01 June 2012

Article 21 of the Town and Country Planning (General Development Procedure) Order 1995
Application for approval of details reserved by conditions 3 & 6 relating to P/145/08/
Butterlees Barn Pagham Road, Lagness, Pagham

Arun District Council have decided to **APPROVE details reserved by this condition**

BUTTERFLIES BARN & LISSNESS
BARN & TYRE GROUND FLOOR PLAN AS PROPOSED
DWG/307/D-05F 1:1000 AS JUL 2008
MALCOLM SIMMONDS ARCHITECTS

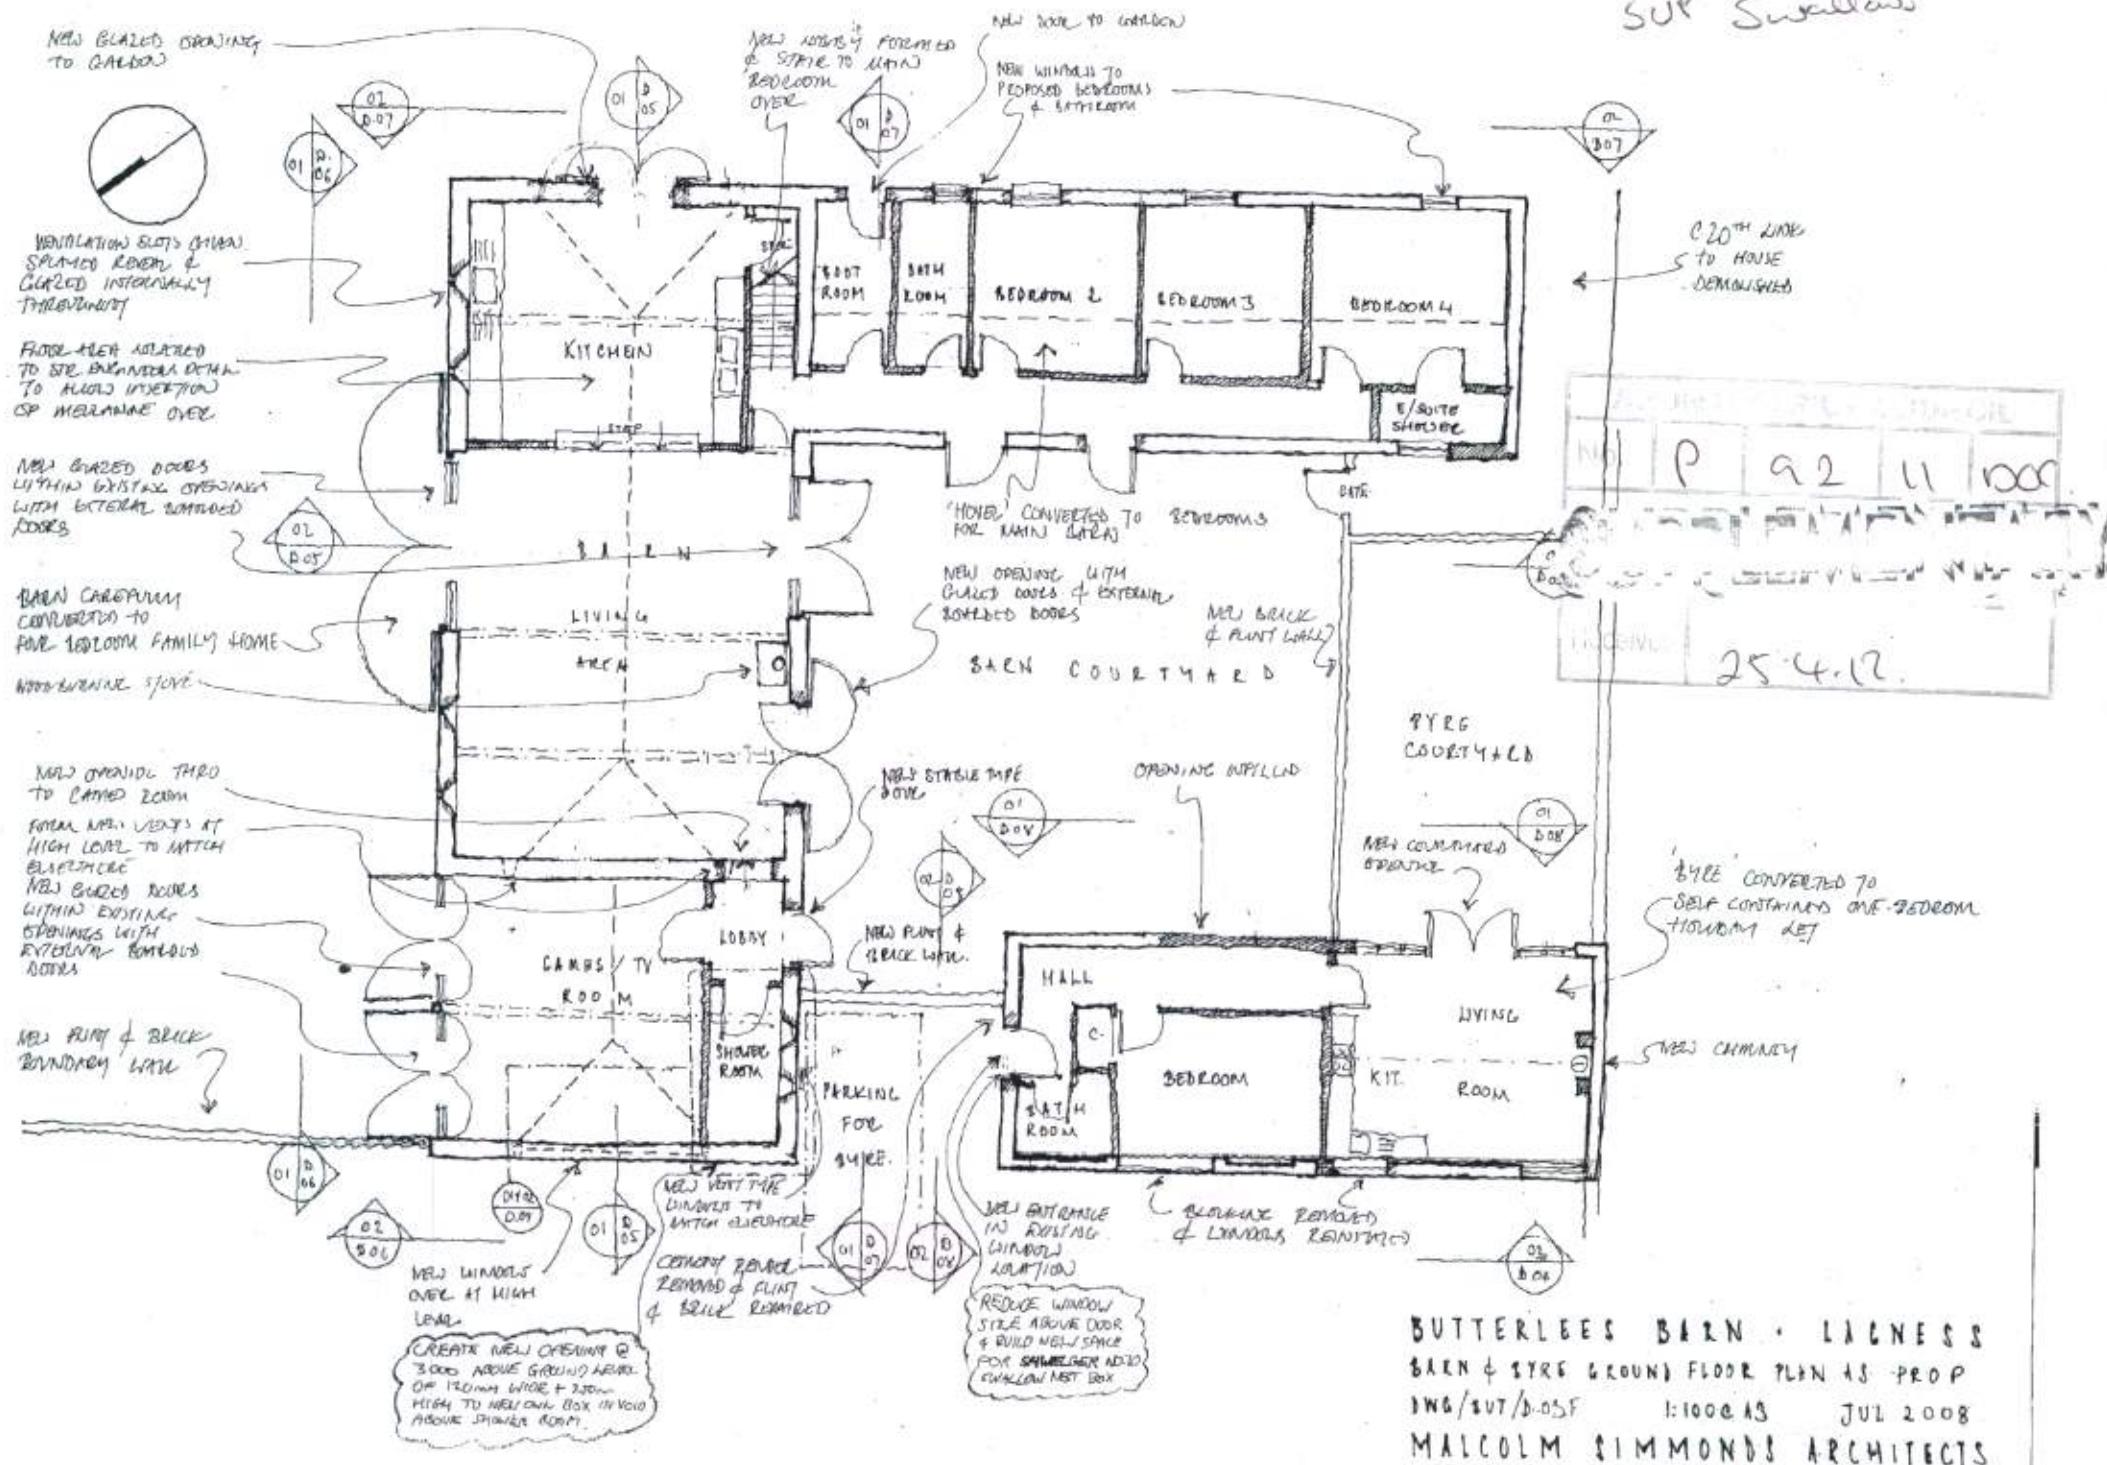
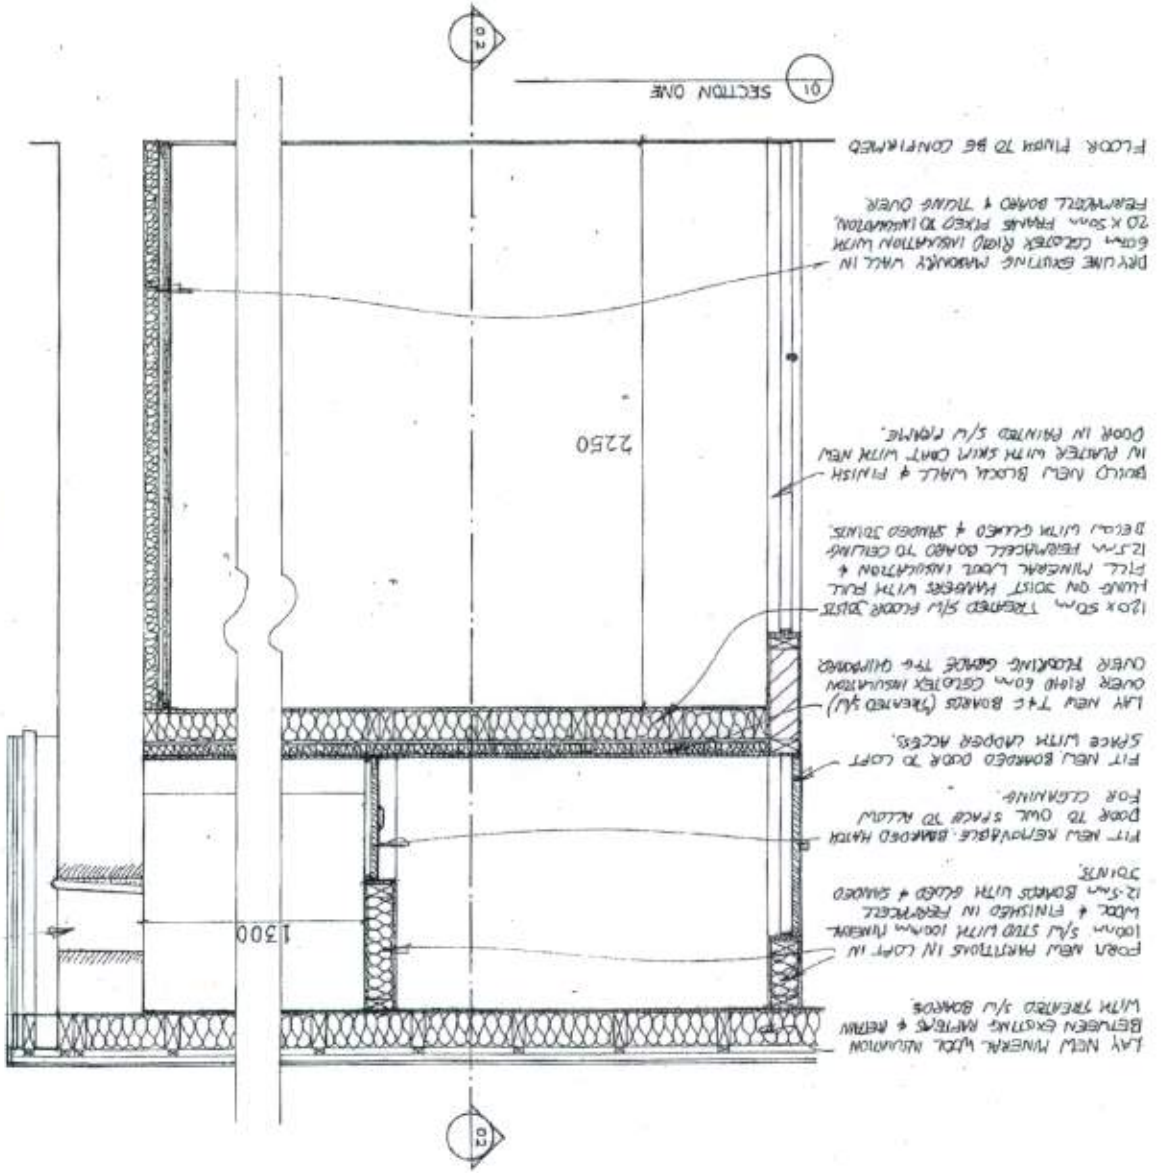
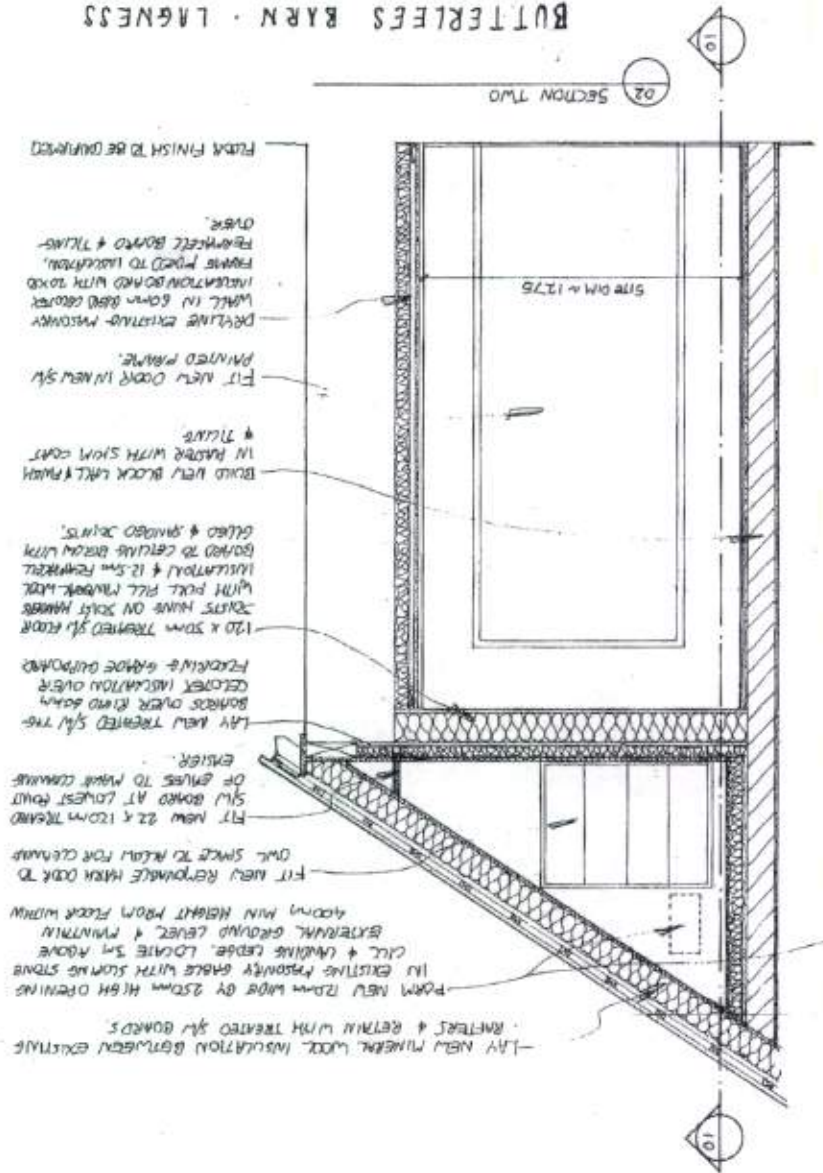
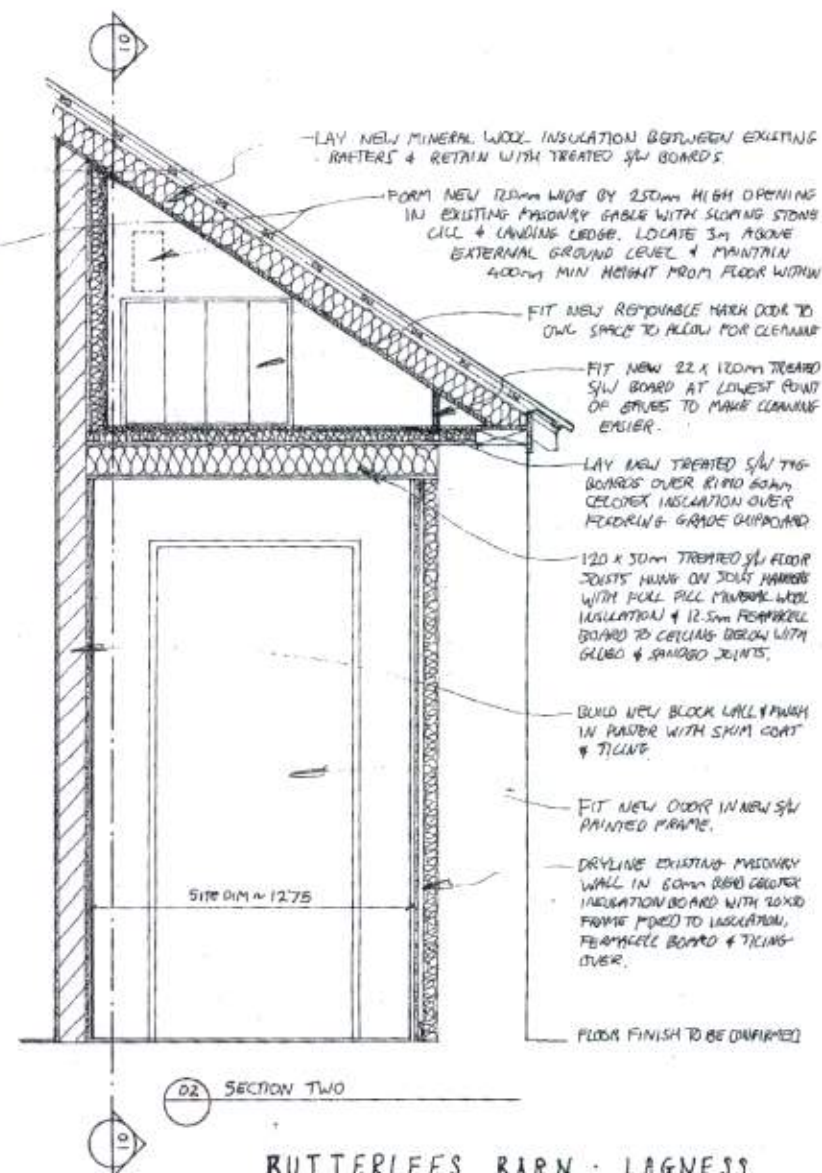
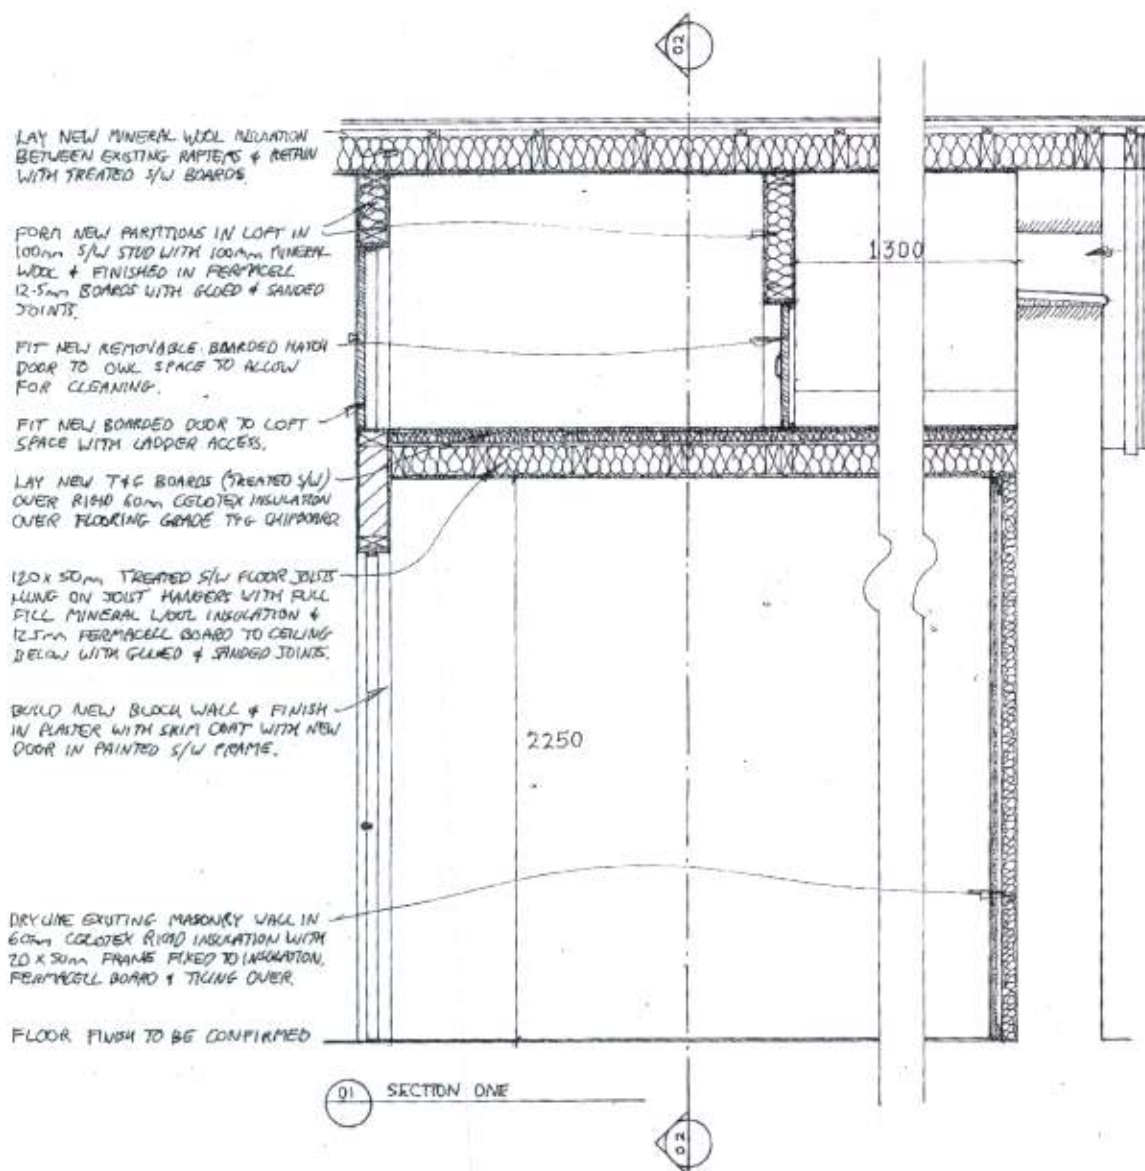
The works to strip potential bat roosting areas such as the roof tiles shall be done under supervision of a licensed bat worker and you should notify the Local Planning Authority in writing including the name of the licensed bat worker and the date that the work will take place. Either an EcoSurv bat box or a Schweglar 1 FR bat tube situated on the South/South West aspect of the buildings. Access and nesting provision (e.g. Schweglar No 10) for swallows should be maintained as per drawing BUT/D.03F
